Submission No.			001		
Organisation Name or Name of Submitter			Albert College Residents Association (ACRA) and Ballymun Road North Residents		
Item No.	Section Ref.	Page No.	Observation Statement	TII Response	
MetroLink Submission: On behalf of ACRA and Ballymun Road North Residents (Barry Conway ACRA Deputy Chair & Jim Deignan)					
1	Context	6	While broadly supportive of the MetroLink Scheme, the respondent believes that the station is in the wrong location... because This section of Ballymun Road is an already heavily utilized area and one of the busiest throughfares to and from Dublin City Centre. An alternative location was proposed in Albert College Park.	<p>TII appreciates the submission and the sharing of concerns/observations related to the Collins Avenue Station. We have reviewed the submission and provided response for the observations/concerns raised in detail below.</p> <p>As outlined in EIAR Chapter 7, Consideration of Alternative, section 7.7.10.7, the assessment undertaken for the Emerging Preferred Route (EPR) identified a preferred route option including the proposed station location in front of Our Lady of Victories (OLV) Church.</p> <p>This location for the sta

Slide 1 – Alternative Station Location at Albert College Park

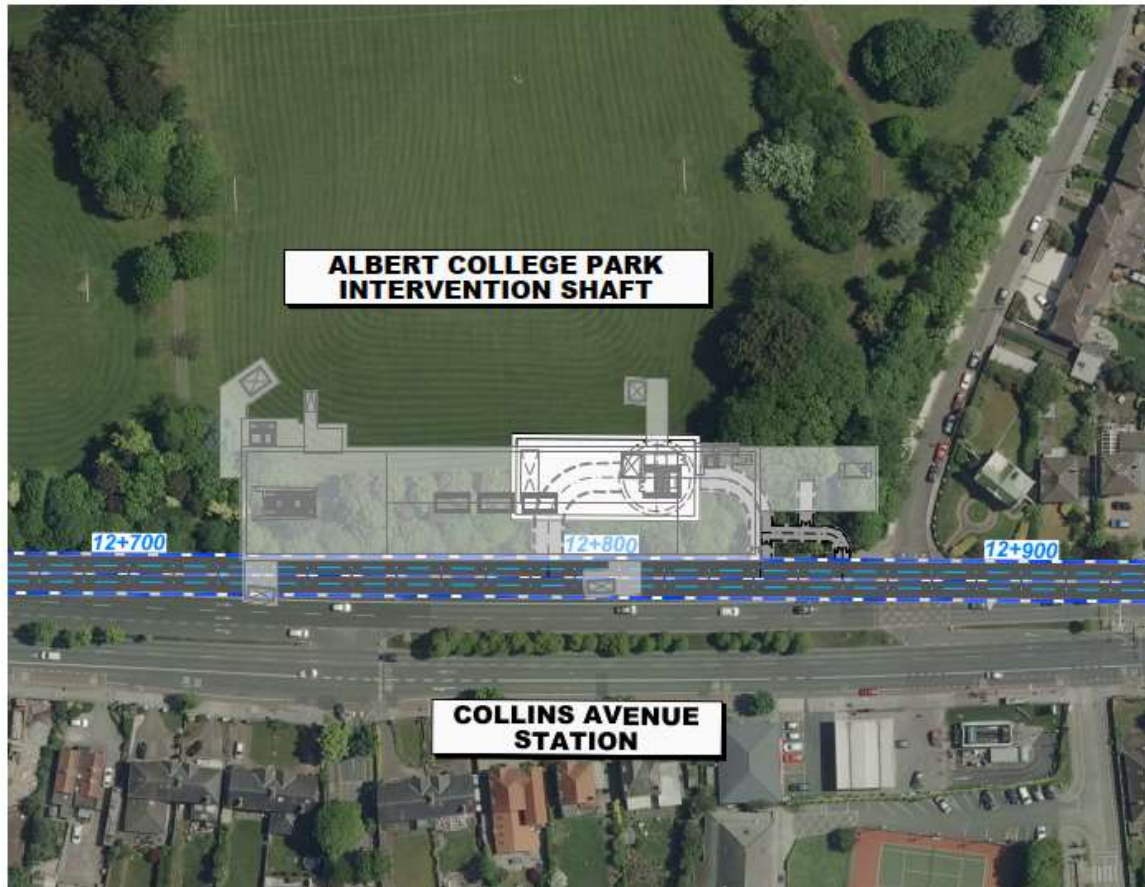
24	Alternative Location	19	During the previous Metro North proposal in 2007 the RPA at that time suggested a number of possible station locations including two park-based options. We are strongly of the opinion that there is merit in examining and considering a variation on what in 2007 the RPA proposed as Option 4 ‘Underground station at the North-West corner of Albert College Park.	Please refer to response (1) above.	
25	Comparison between the proposed Collins Ave Station and the previous Griffiths Park Station designs	26	There are a number of common denominators between the two locations. Both are sensitive receptors due to the presence of (three) schools at each location as well as having an impact on sporting /green amenities. In addition, Collins Avenue station has the added negative effect on those groups mentioned previously. We believe that stakeholders in our catchment area, particularly children and parents at OLV schools, senior residents at Albert College Court, churchgoers, Ballymun Road and Albert College Estate residents are no less deserving of the same considerations which were largely based on concerns relating to safety and environmental impacts, as was afforded to stakeholders in the Griffith Park station catchment area. Station relocation was clearly seen as the correct and only action to take at Griffith Park and we believe that given the similarities between the two sites, the same actions are justified at the Collins Avenue station which is after all just one kilometre further up the road.	Please refer to responses (1) above.

26	Requirement for an Intervention Shaft:	28	If Albert College Park is the revised location of the station an alternative location for the ventilation shaft is also proposed. We propose that the new location for this ventilation shaft should be moved north of the Collins Ave junction, between the Dentist and Ballymun Library.	An alternative location for an intervention/ventilation shaft north of Collins Avenue is not included for in the RO Application.	
27	Conclusion	31	We submit that accommodation of everybody's interests can and should be achieved by a well-designed park-based solution which allows the most judicious and economic use of the parkland. We feel this will serve both the interests of those patrons of OLV Schools and Church, Local Residents and indeed commuters from outside the area, who could all potentially suffer a significant loss in their quality of life and their enjoyment of their properties if the wrong decision is taken.	TII have set out in the above responses the rationale for the proposed location of Collins Avenue Station and hence the need for an intervention shaft south of the proposed Collins Avenue Station, including the preferred location for this shaft in Albert College Park, and the environmental mitigation measures that will be employed to mitigate temporary environmental impacts, including traffic management and access, noise and vibration and air quality.
